October 1, 2024

**SUBJECT: Kinch Subdivision (MS-204)
Engineer's Certification Letter – Subdivision Improvements**

PLAN & PROFILE
KINCH COURT

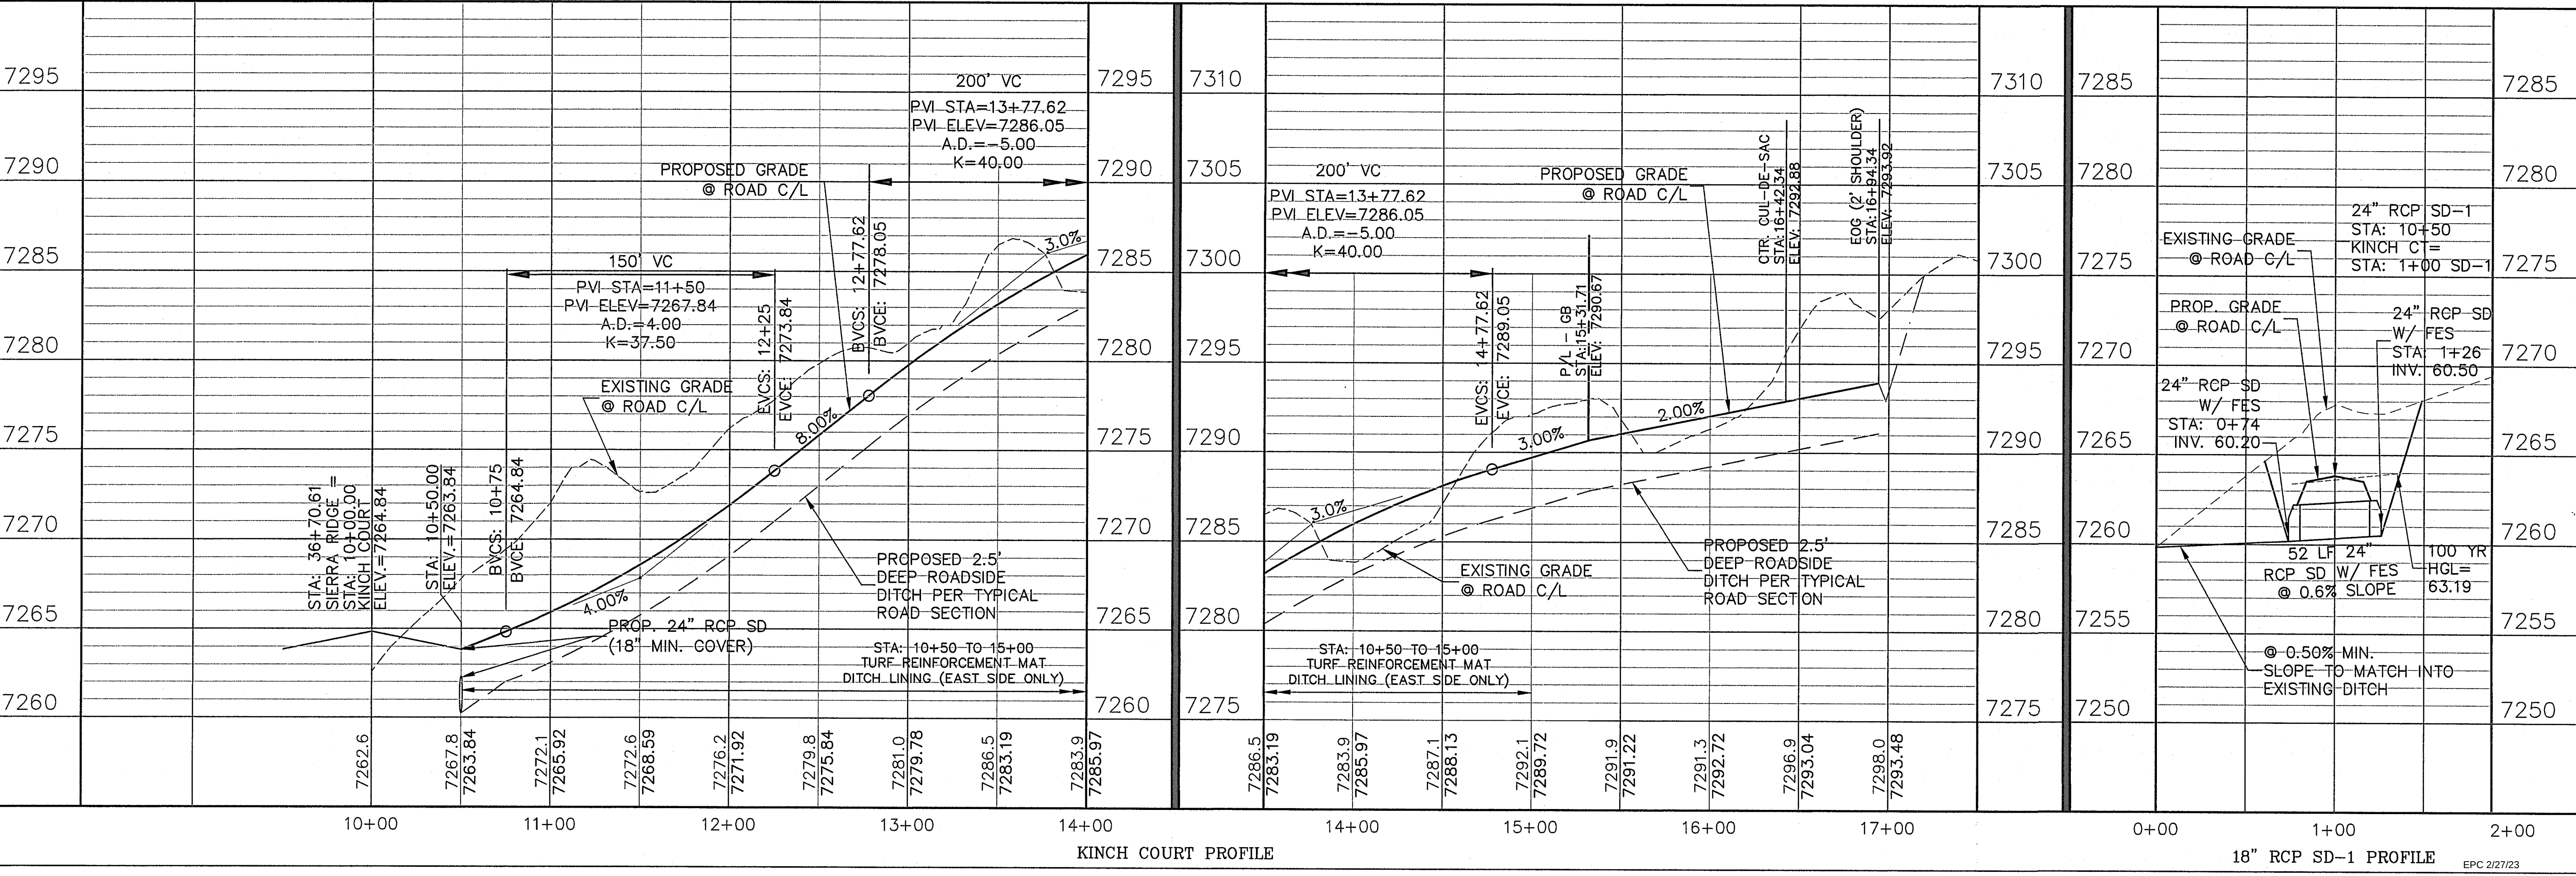
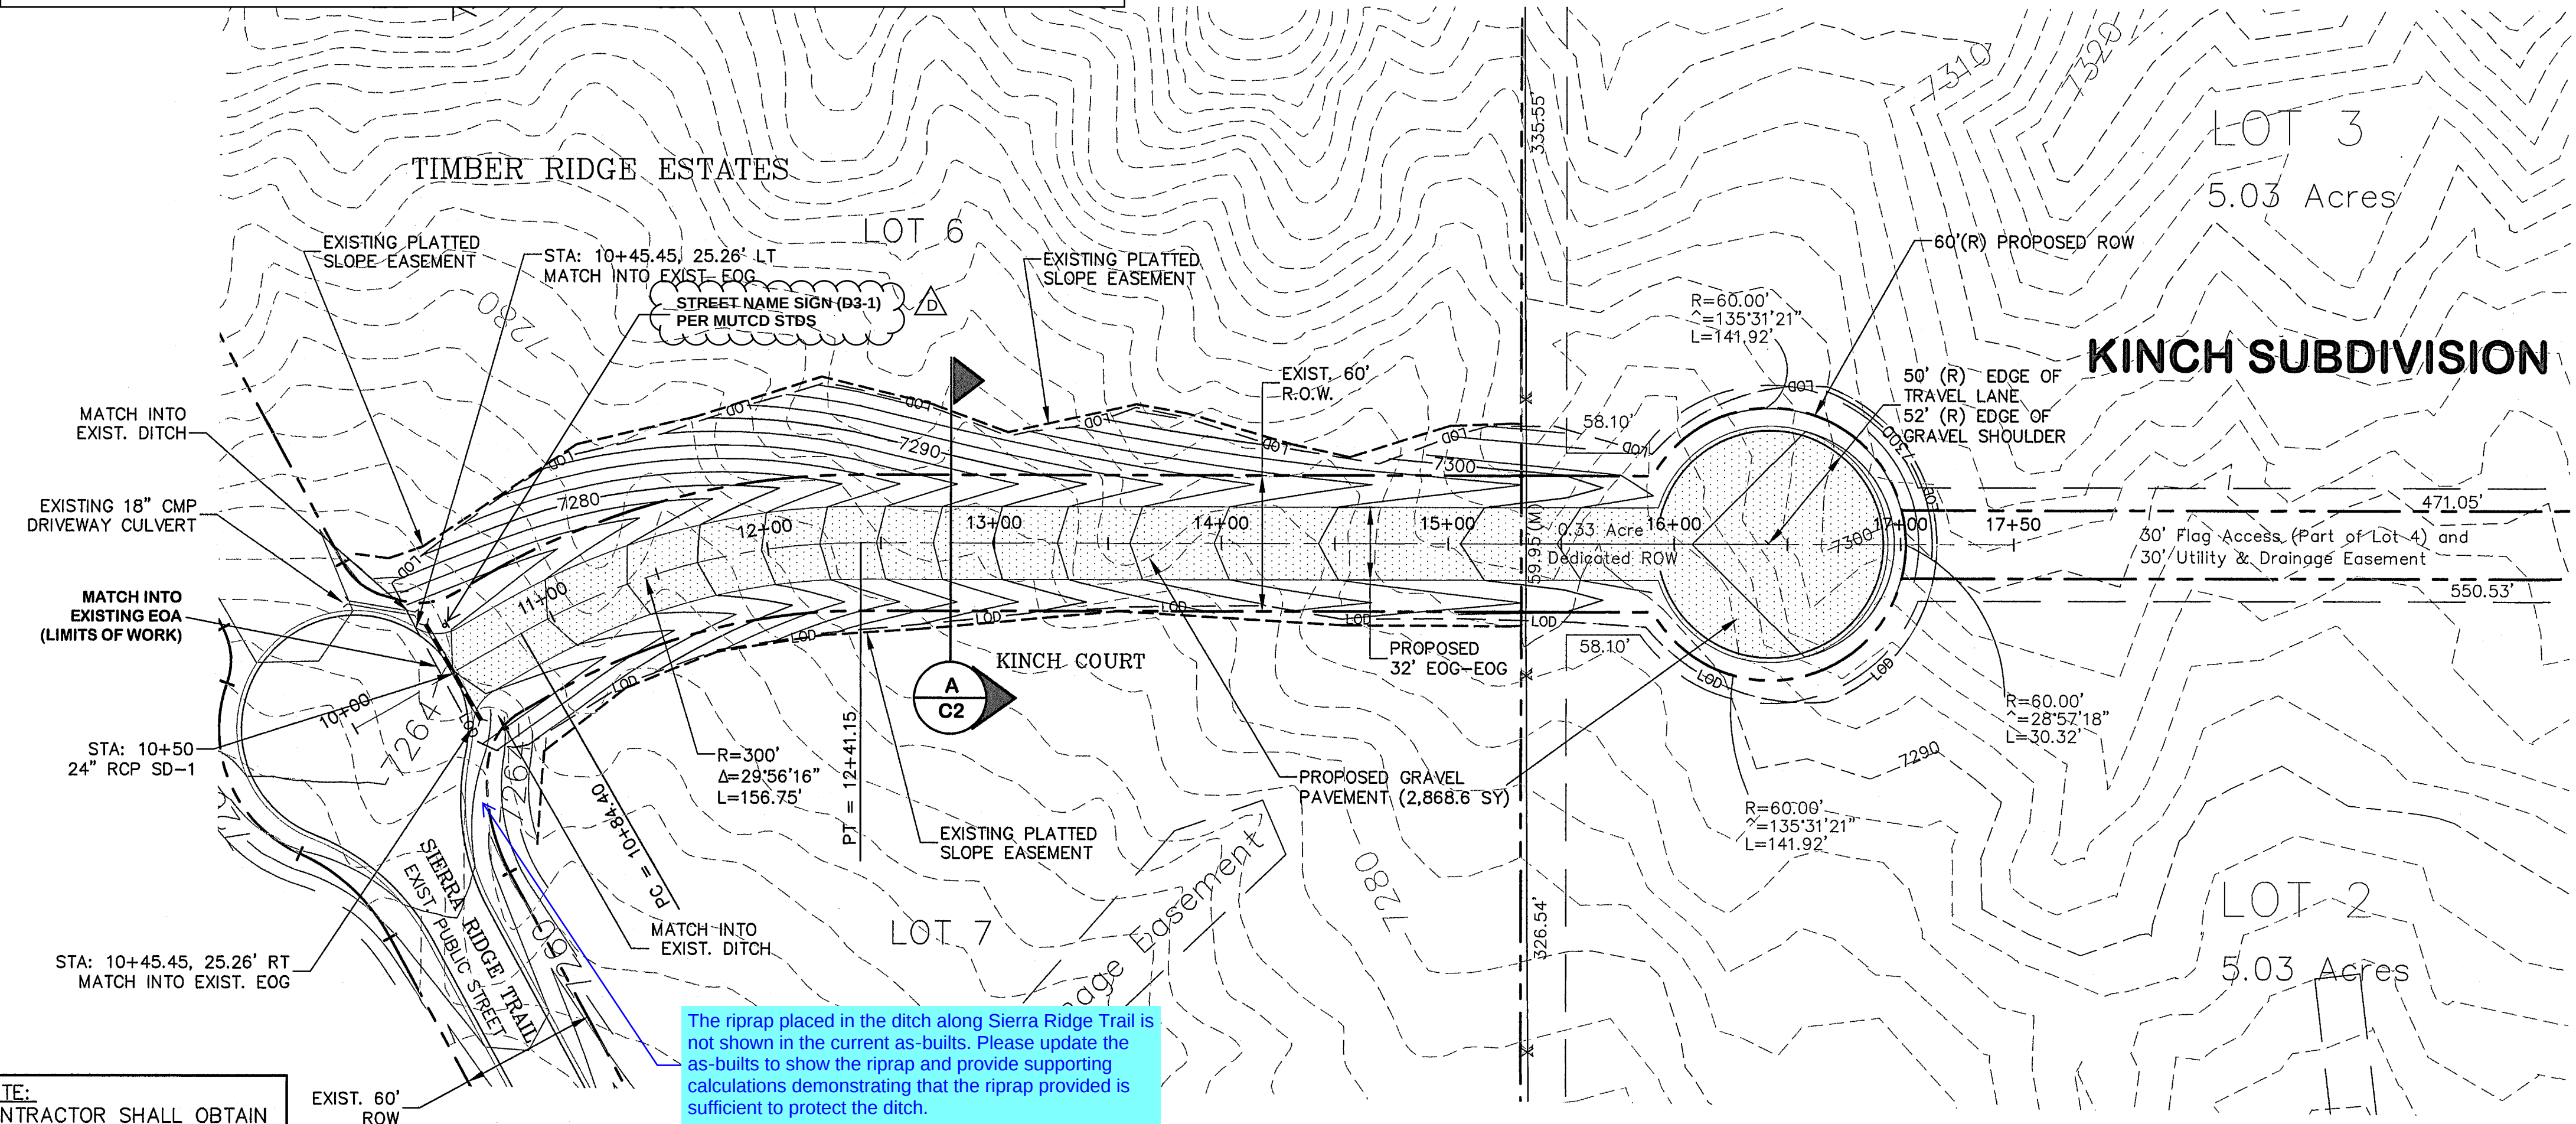
Please specifically reference the Runoff Reduction area (just the RPA) since RR is a PCM. That way it is clear that this letter is certifying a PCM, not just roads and ditches.
